Sutherland Hospital Operating Theatre Upgrade (SSD-11099584)
Request for additional information

I refer to the State significant development (SSD) application for the Sutherland Hospital Operating Theatre Upgrade (SSD-11099584). The Department requires additional information regarding the proposal to enable progressing the assessment of the application.

PROPOSED LANDSCAPE PLAN

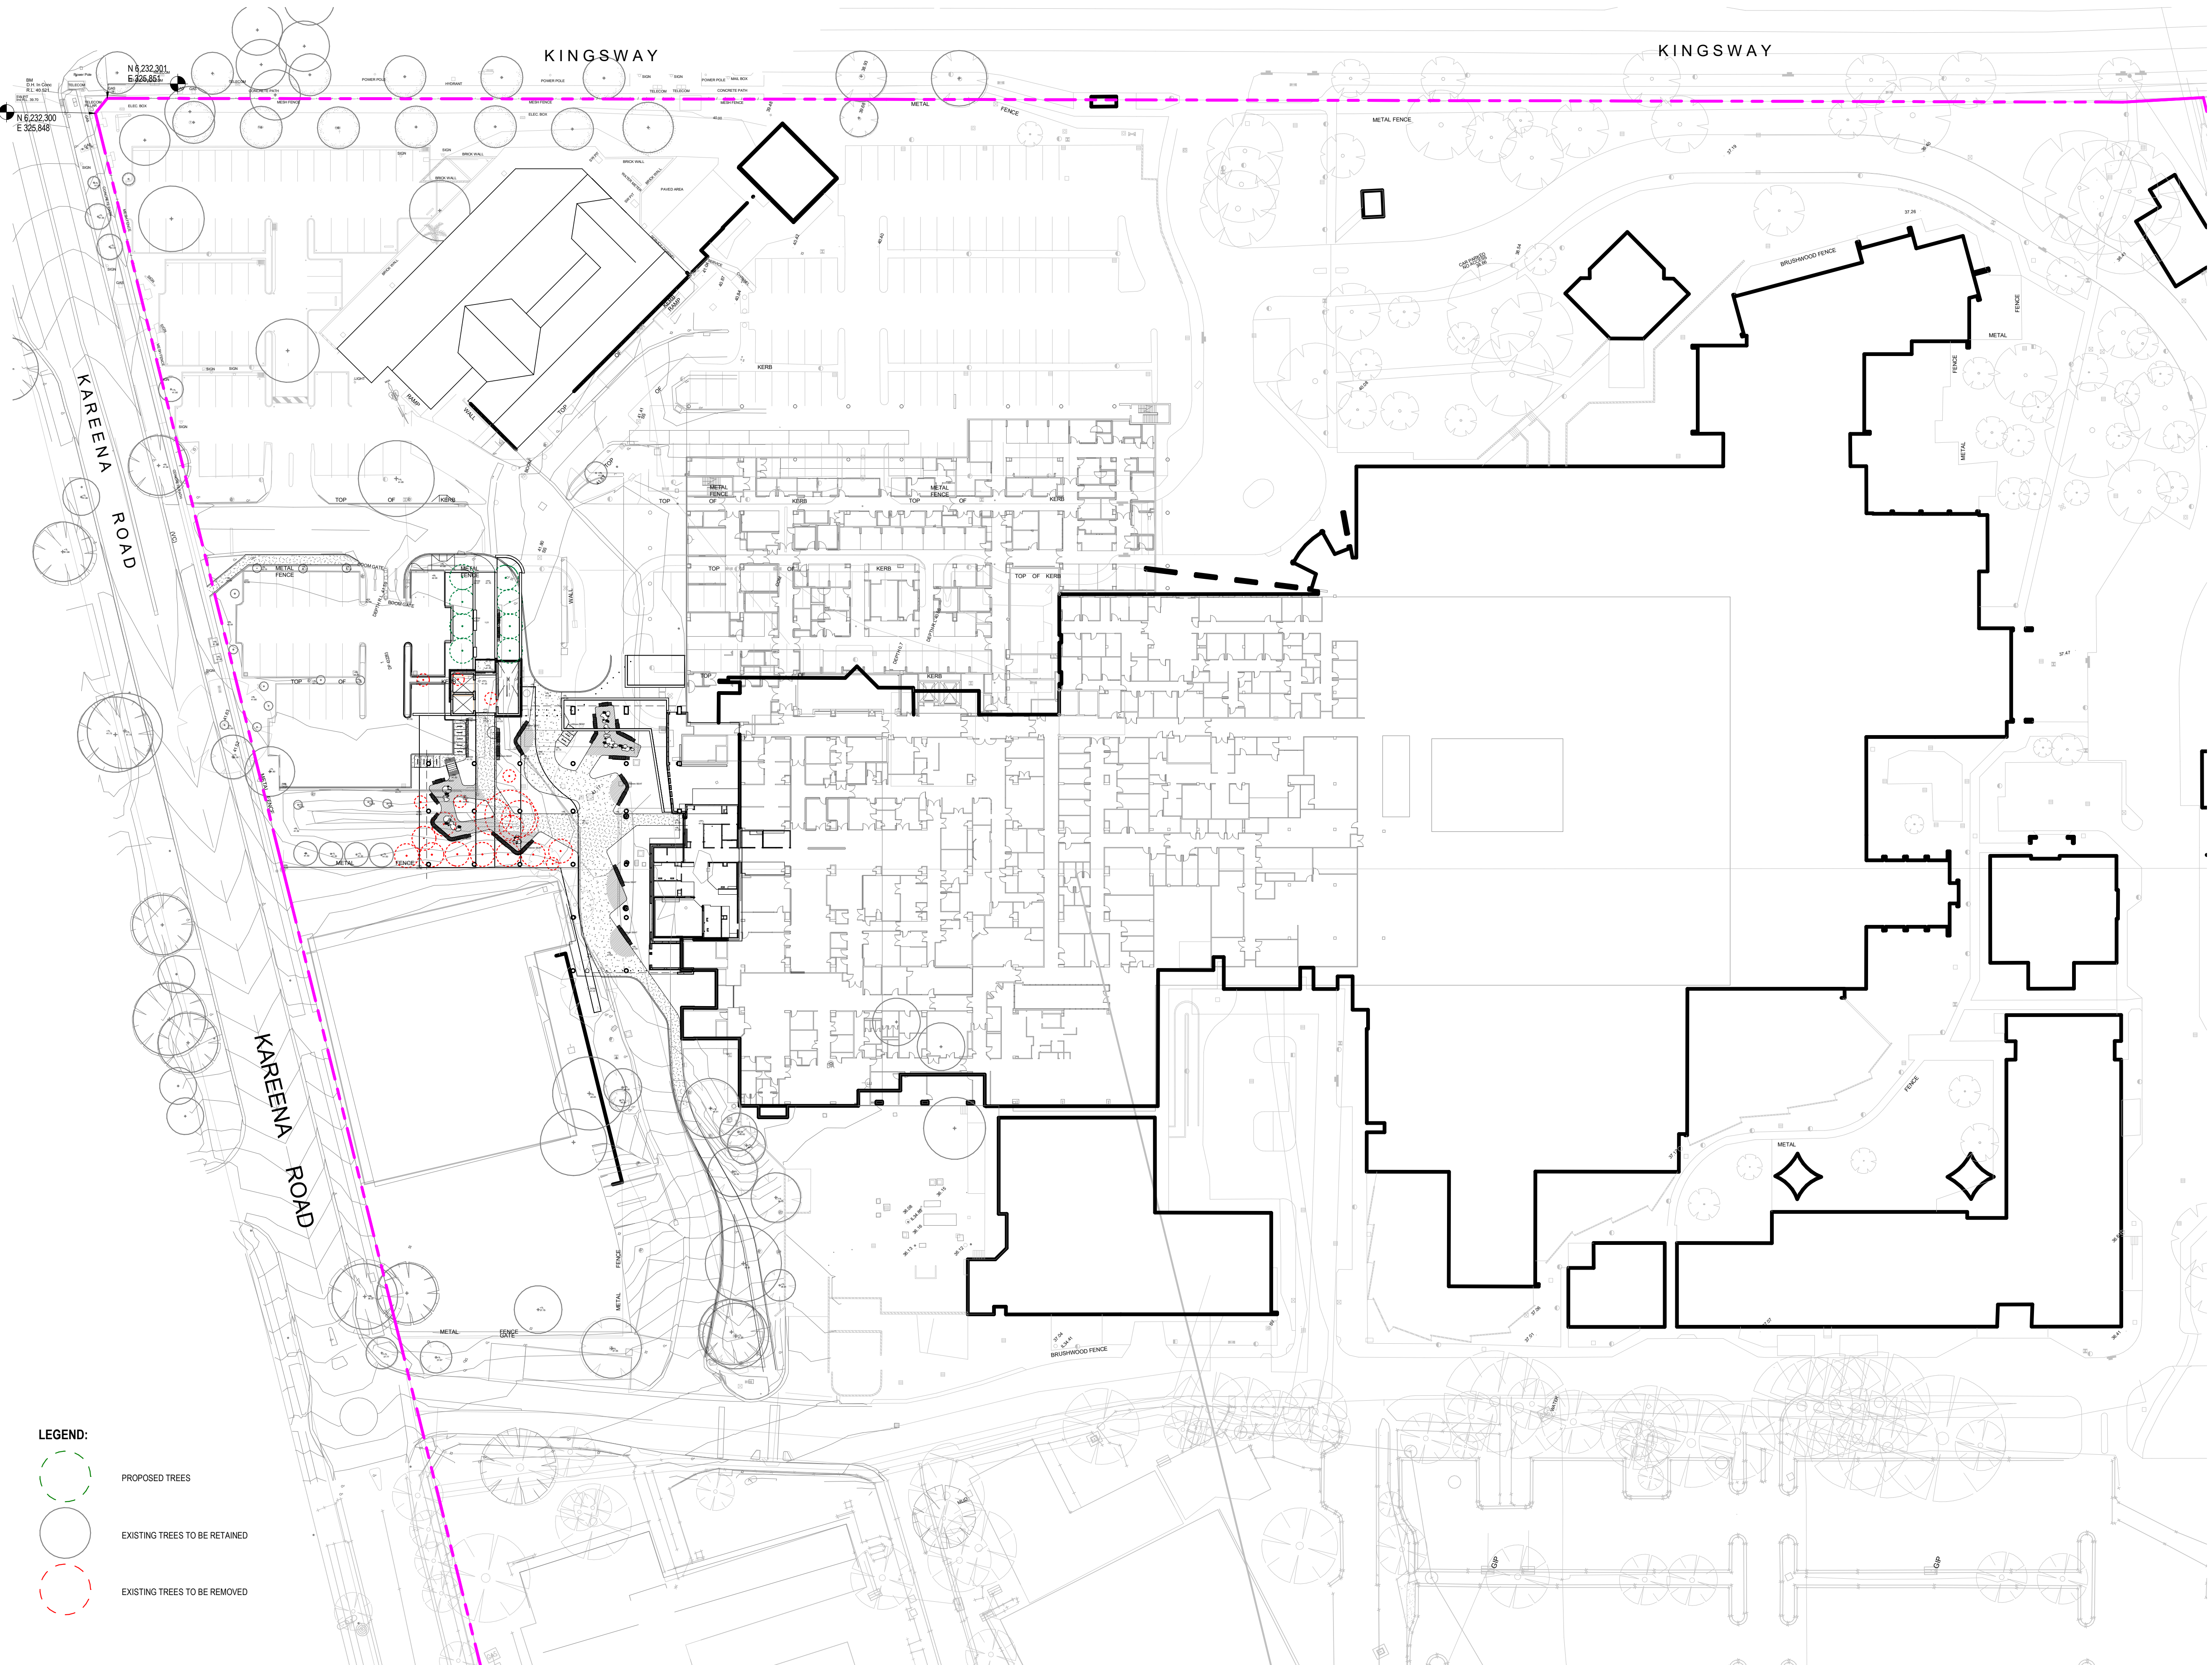
- confirm the intended use of the Level 2 room located to the south of the existing fire stairs.
- clarify concerns regarding the impact of the planting of four street trees on sightlines from the Ambulance Station.
